From: [REDACTED]
To: [Norfolk Boreas](#)
Subject: Norfolk Boreas Project EN010087
Date: 06 May 2020 19:02:35

These are my comments, on the comments of the applicant on deadline 8 submissions. The applicant suggests that: *"The screening seen in the visualisations of Viewpoint 3 and 7 relates partly to landform and partly to existing tree cover. In respect of Viewpoint 3, the mature trees around Lodge Farm (approximately 18m tall) reduce the extent to which the onshore project substation would be visible."*

Figure: 29.37a	Drawing No: PB5640-005-029-037				
Revision:	Date:	Drawn:	Checked:	Size:	Scale:
01	14/02/2019	LA	JP	A3	Multiple
02	21/02/2019	LA	JP	A3	Multiple

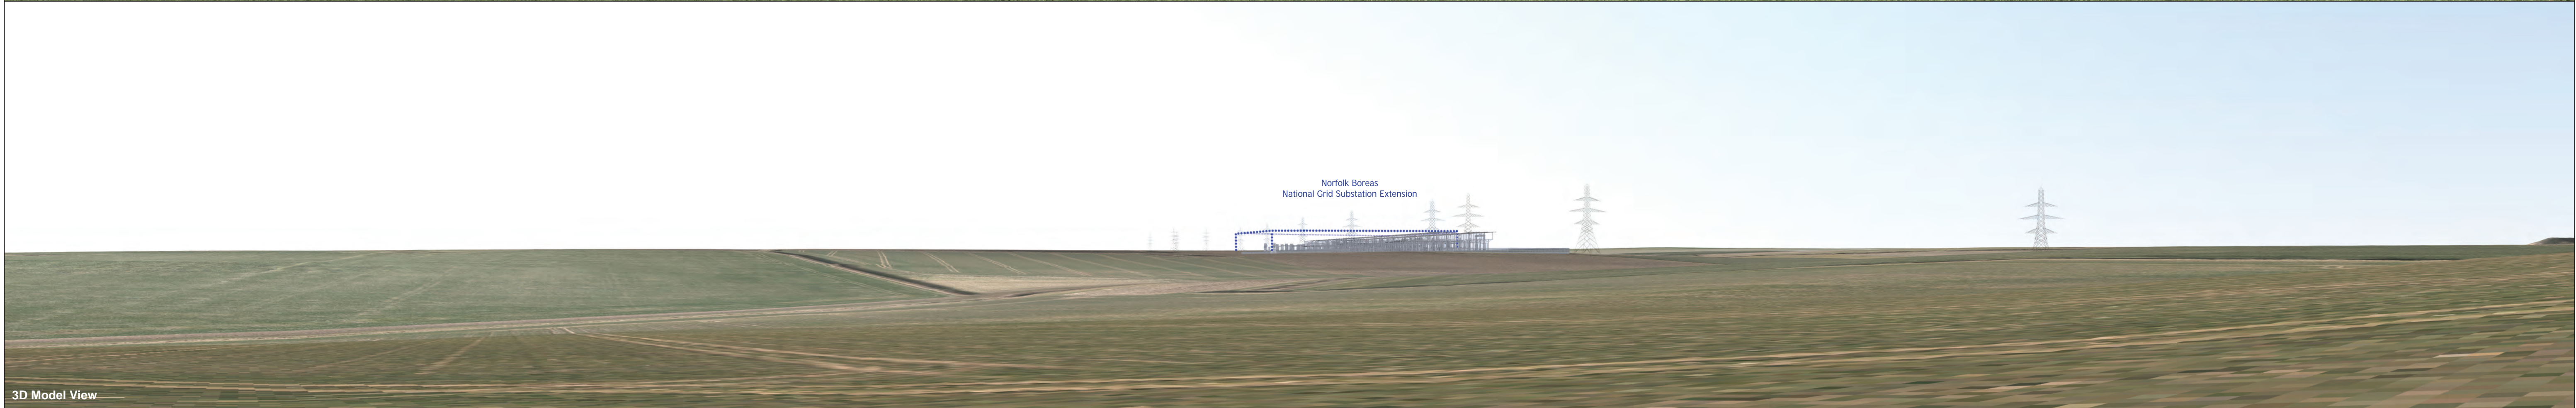
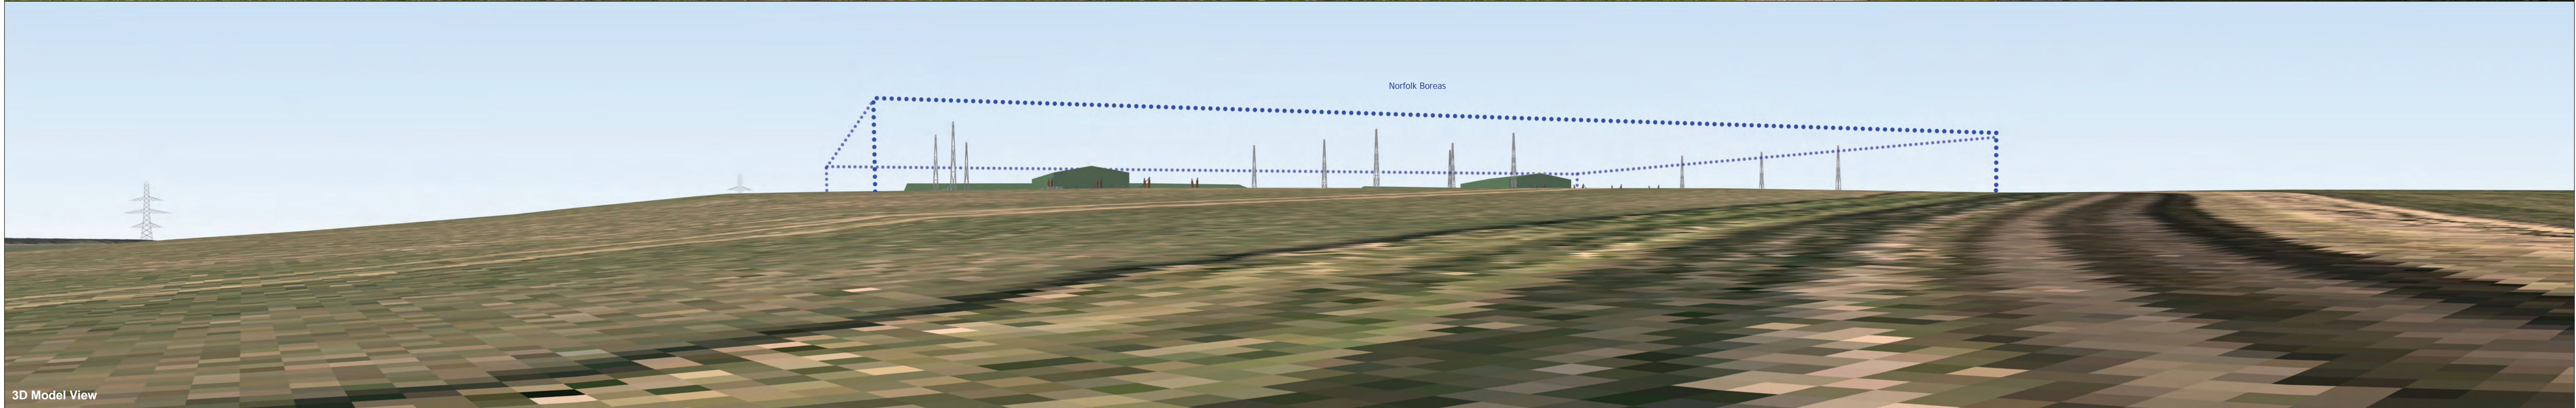
The problem at viewpoint 3 is with the representation of land form only. The 3D Model View, fig:29.37b 2of2. produced by OS terrain 5. shows the converter halls mostly hidden by a land form. All diagrams suggest the halls to be more visible. The applicants latest cross section diagram supplied with their comments on deadline 8 submissions, show the halls 3/4 in view, using the land form contour, ignoring the trees for now. The Model View should therefore also show the halls 3/4 in view. This is important to gauge the mitigation needed.

Photo montage fig:29.37c 3of3. must be based on the 3D Model Views produced by OS Terrain 5. as it shows the east converter hall totally screened by land form and a hedge, when actually the land in a NE direction from Lodge Farm rises from 70m to 73m. The converter hall again should be 3/4 visible in the montage.

The applicant refers to Lodge Farm trees, for the first time in these considerations, and includes them in their latest cross section diagram, suggesting they are present, and affecting the 3D Model View to give the screened effect, when that view is of land form only. This adds weight to the theory, that OS terrain 5. confused and combined the trees and ground level, to a degree, to produce an artificially high land form.

The stand of trees at Lodge Farm is 110m wide, and as such would screen 1 converter hall. In the viewpoint 3 visualisations, the east hall would be in full width view. In scenario 1, 3 halls out of the 4 would be in view.
